Our Ref: FG/161/14/PL
Your Ref:

Town & Country Planning Act 1990 (as amended)
Town and Country Planning (Development Management Procedure) (England) Order 2010 (as amended)
Application for Planning Permission

Development	Proposed demolition of three buildings and erection of replacement workshop and machinery store
Location	Onslow Caravan Park Onslow Drive Ferring Worthing

Sheet 1 – Location Plan

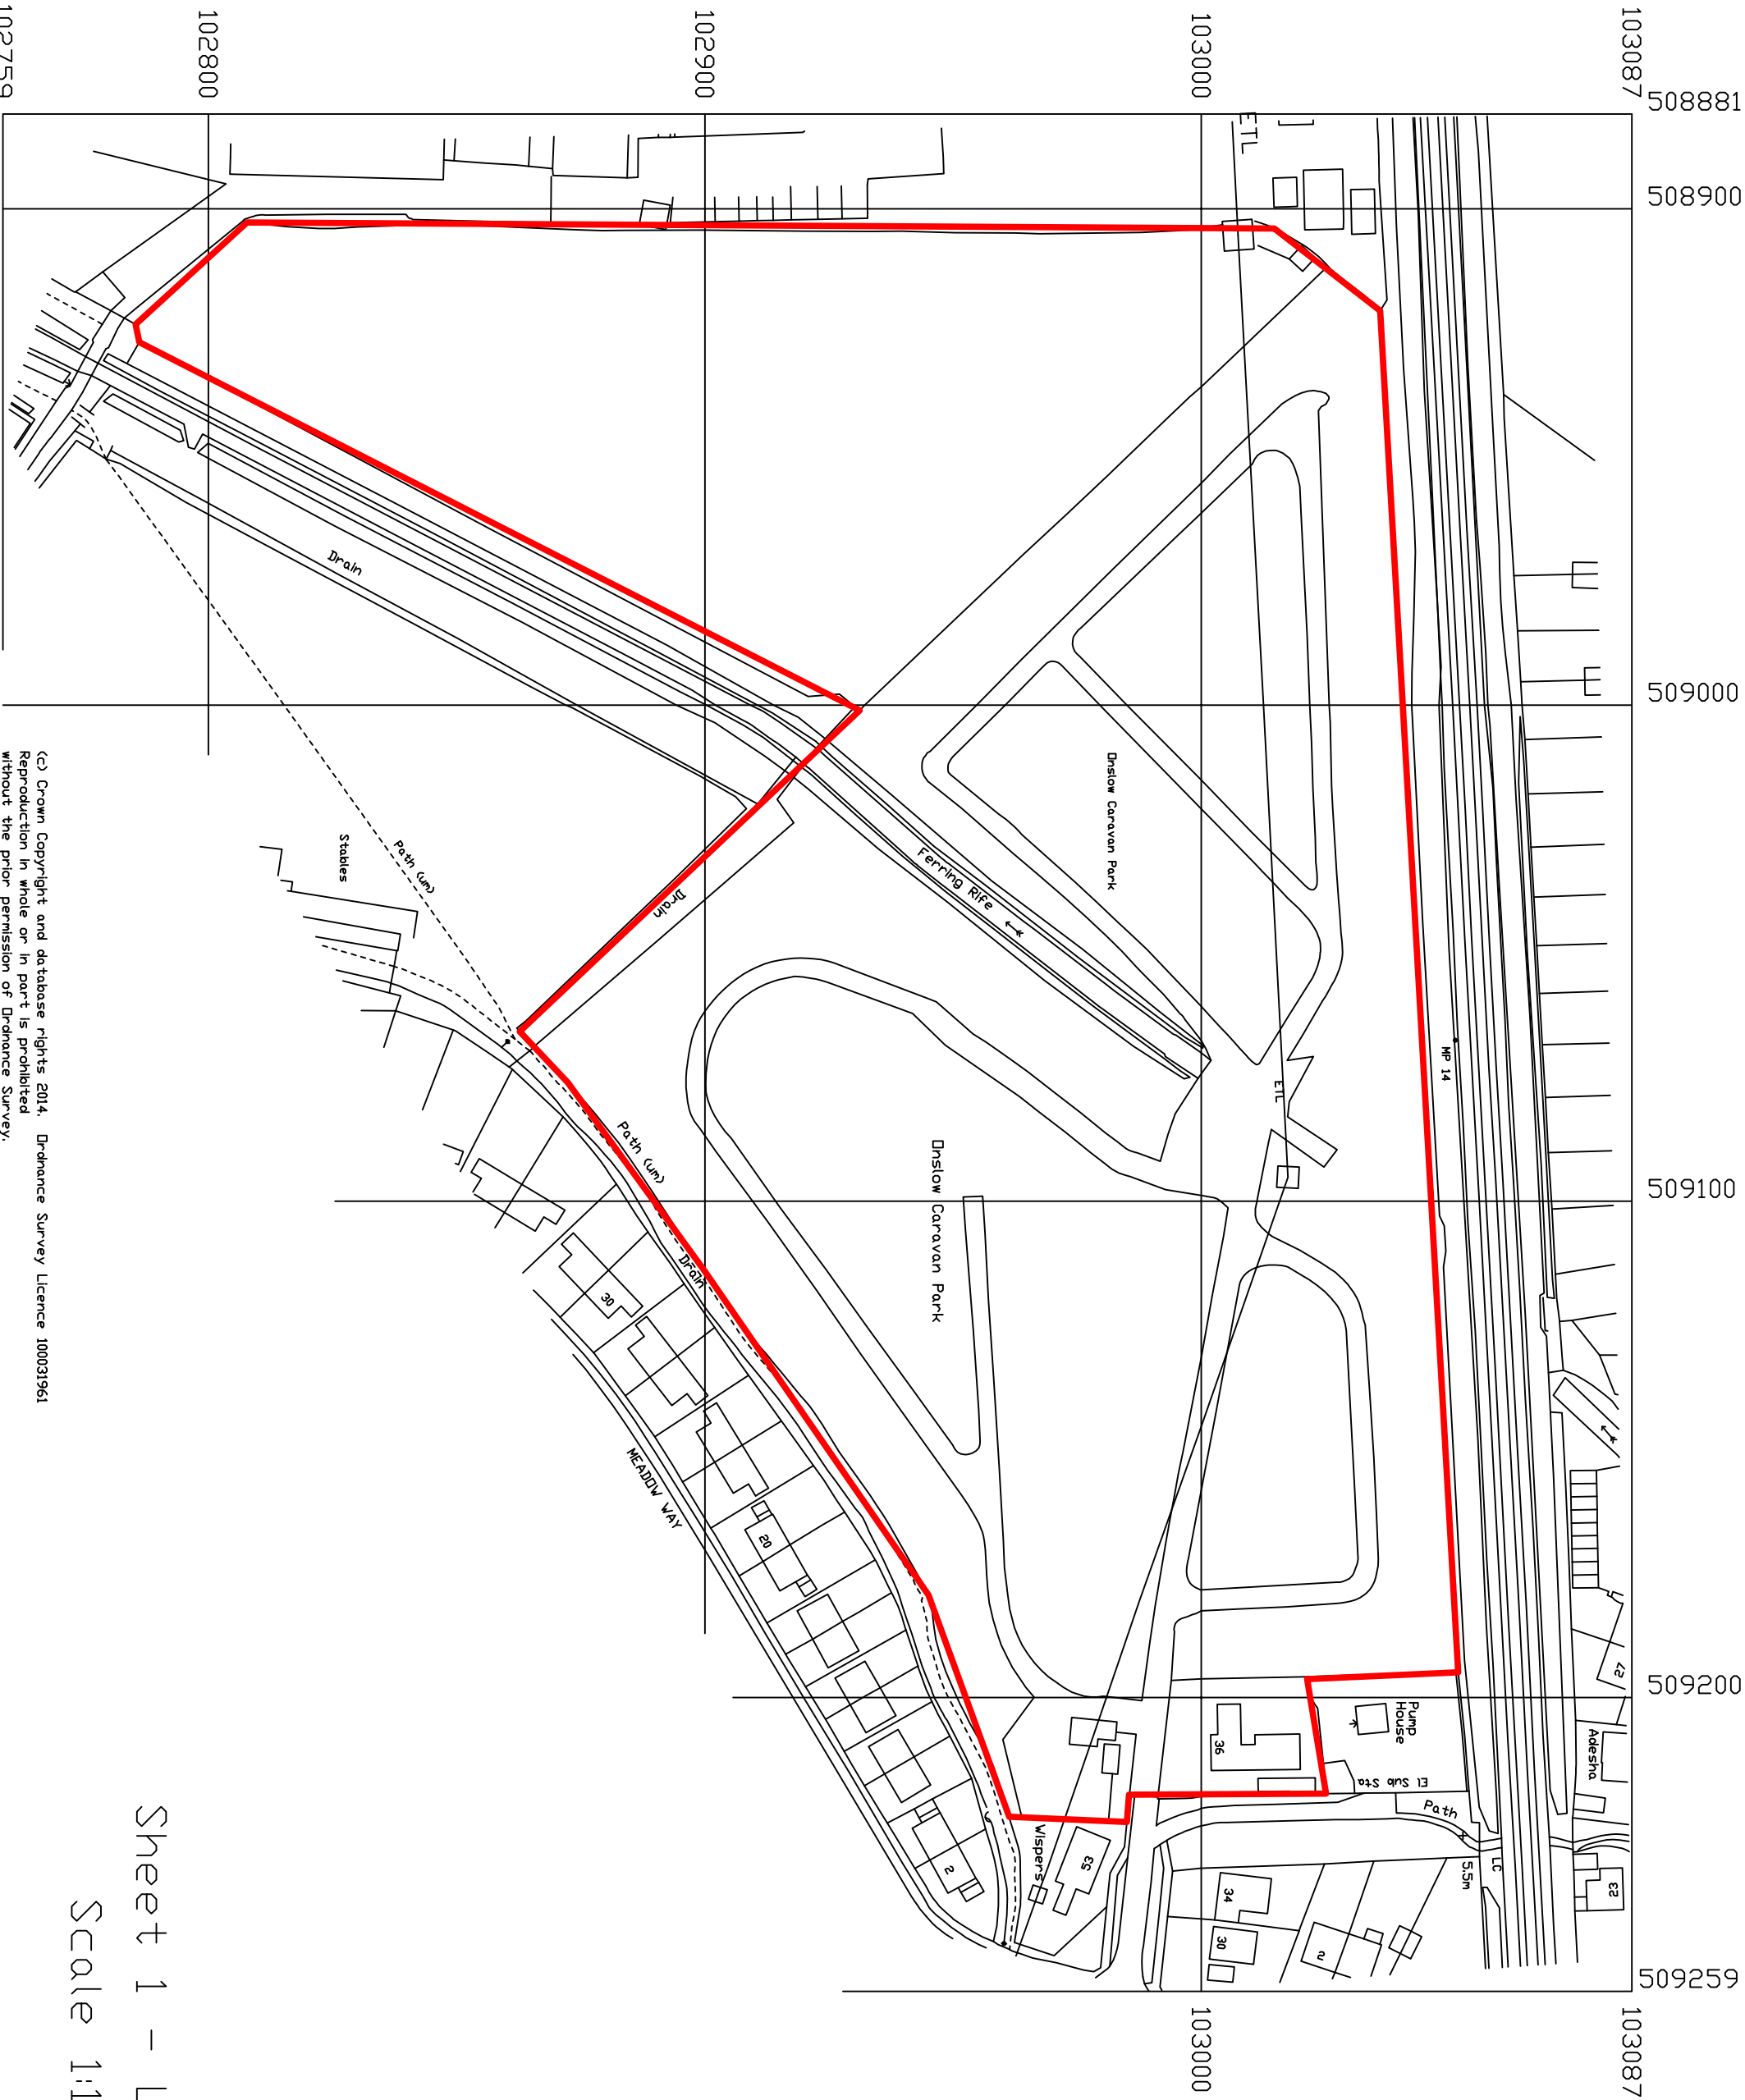
Please submit 1 electronic or 3 paper copies of an amended location plan at a scale of 1:1250 to include 2 road names and a North Point. Further details of what must be included on the plan can be found in the National Validation Requirements.
